**Exhibited EIS - Inland Rail Project - Parkes to Narromine**

I refer to your request dated 17 July 2017 seeking comment from the Office and Environment and Heritage (OEH) on the exhibited Environmental Impact Statement (EIS) for the Parkes to Narromine Inland Rail project. OEH understands that the proposed project will result in the clearing of 75.78 hectares of native vegetation across nine plant community types (PCTs), including the clearing of 63.07 hectares of threatened ecological communities (TECs). The biodiversity offset credit requirement has been calculated to be a total of 2,561 ecosystem credits and 491 species credits for the koala.

**ATTACHMENT A**

# Parkes to Narromine Inland Rail Project – Environmental Impact Statement

**Figure 8.2e**  
Construction work stages, work areas and compounds

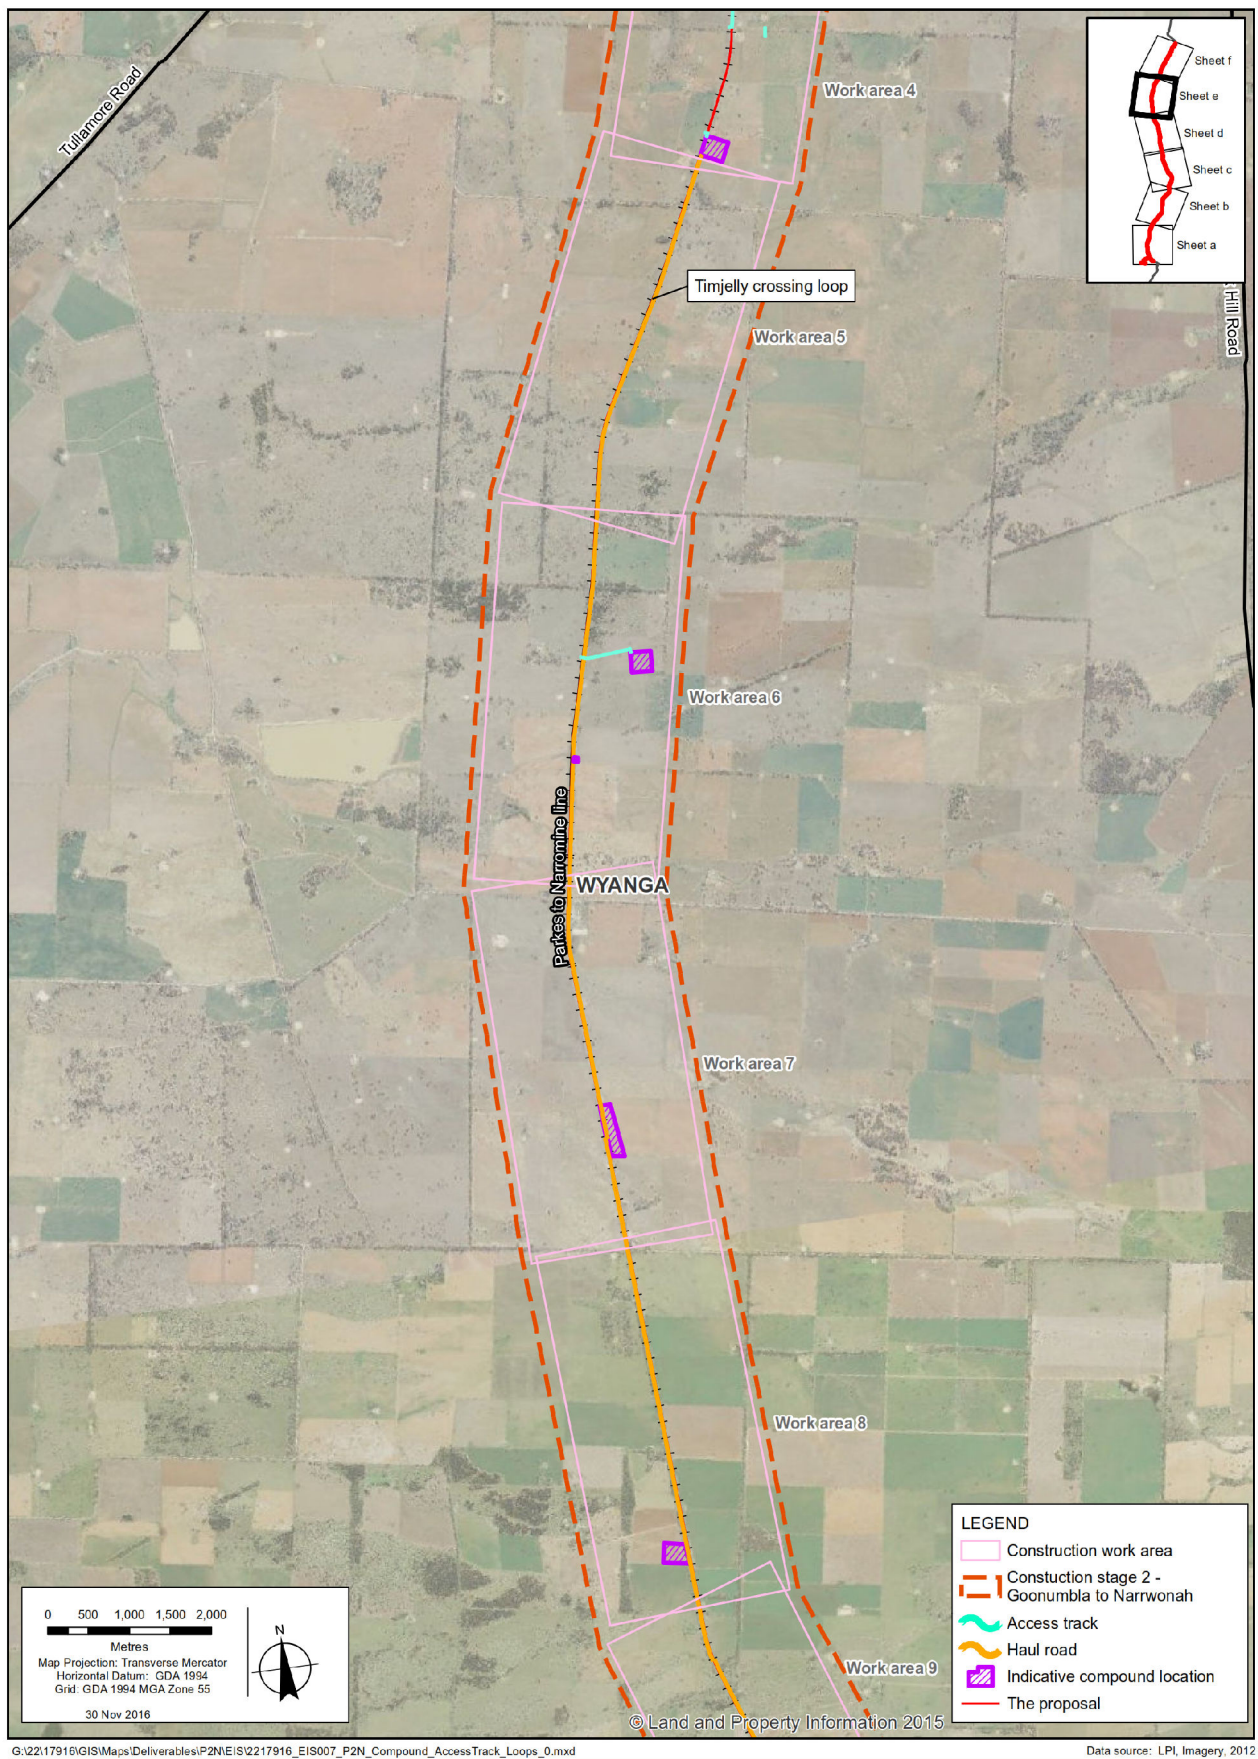
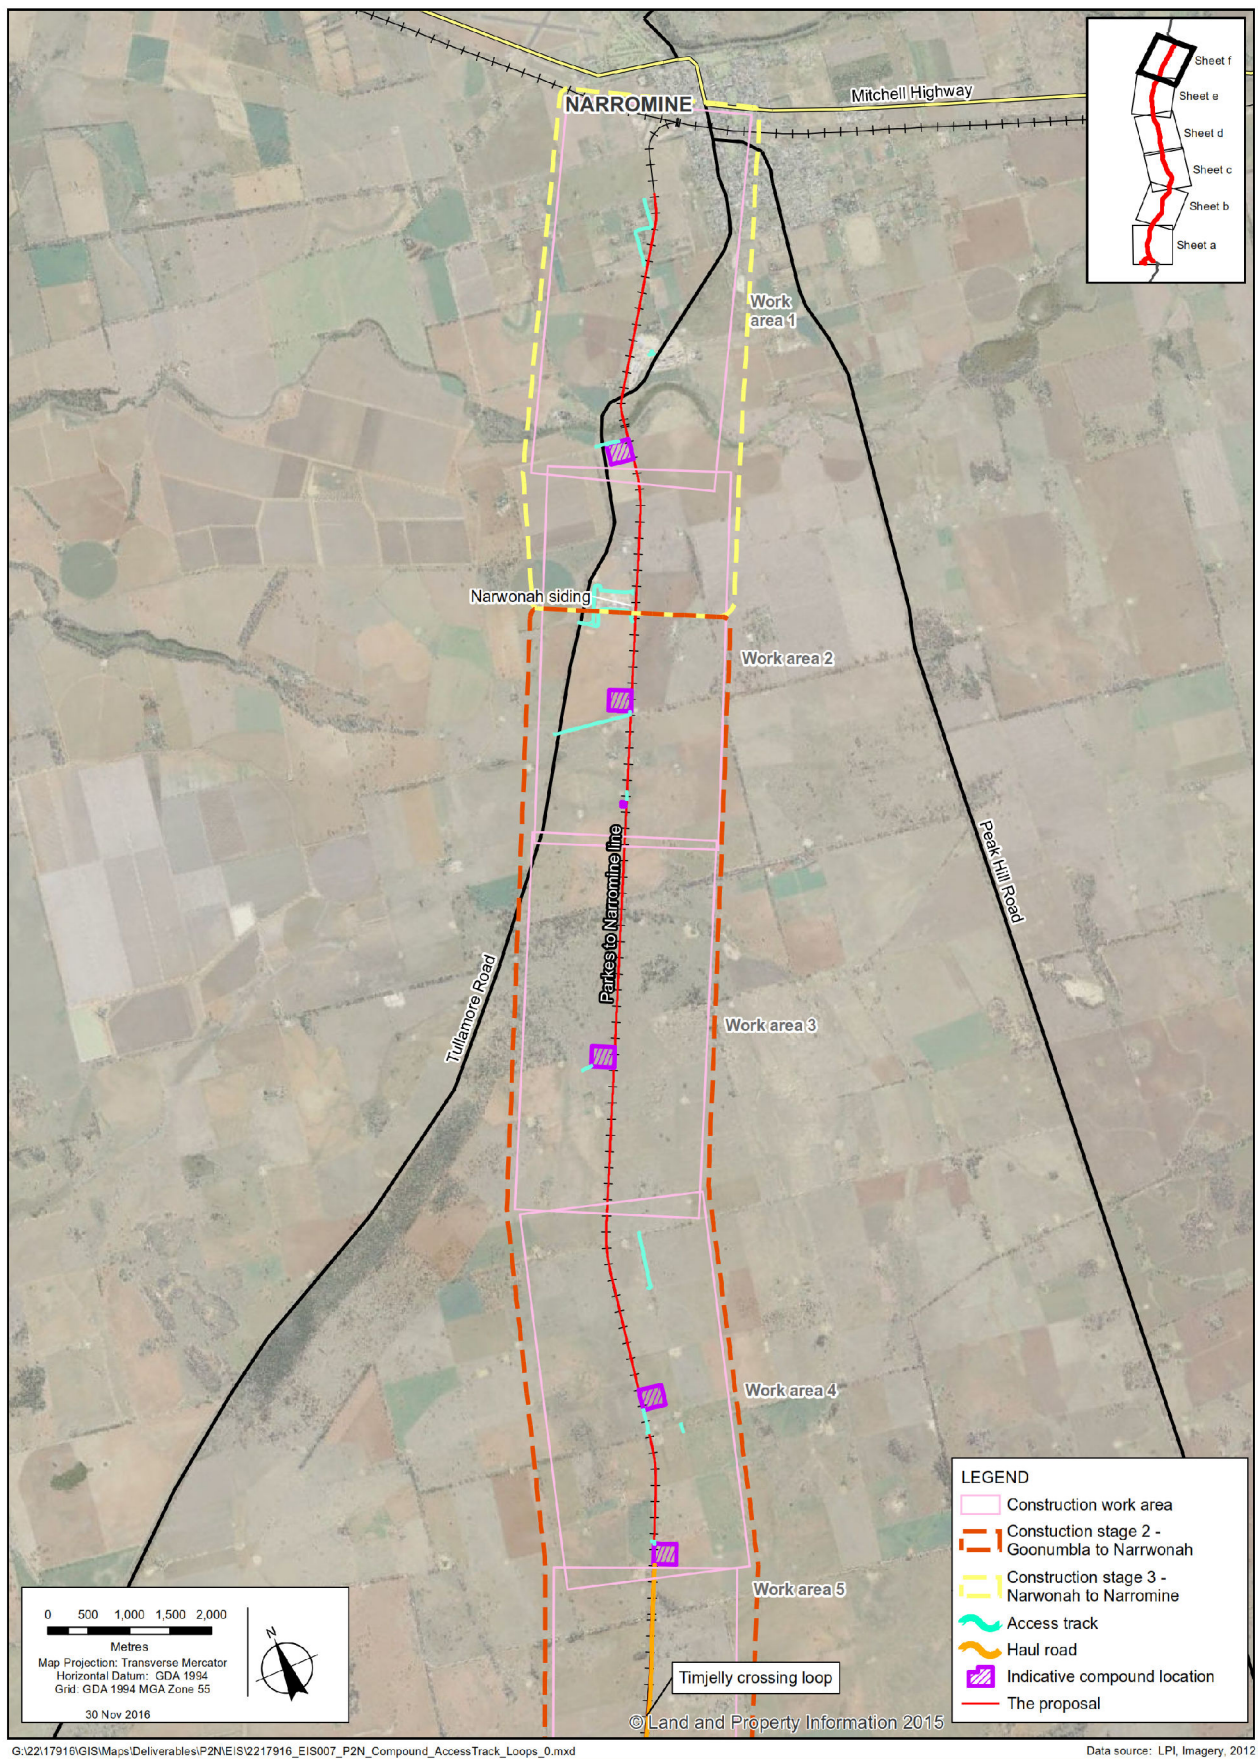
Most of the temporary impact zones identified in Figures 4.1A to 4.1E in the Biodiversity Assessment Report (BAR) are located within areas of non-native vegetation; thereby successfully avoiding impacts on biodiversity values. However, there are some compounds (in work areas 3, 11, 18 and 22 as displayed in Figures 8.2a-f in the main report) which are situated within areas of native vegetation, including threatened ecological communities (TECs). In each of these instances areas of non-native vegetation occur in close proximity, however no explanation has been provided as to why the compounds could not be re-located to these areas.

OEH understands that there may be some flexibility in the final location of the compounds. The proponent should make every attempt to avoid impacts on native vegetation and in particular TECs and threatened flora and fauna. Where these impacts cannot be avoided and are appropriately justified, the proponent will need to assess the impacts using the FBA and offset them with the corresponding biodiversity credit requirements.
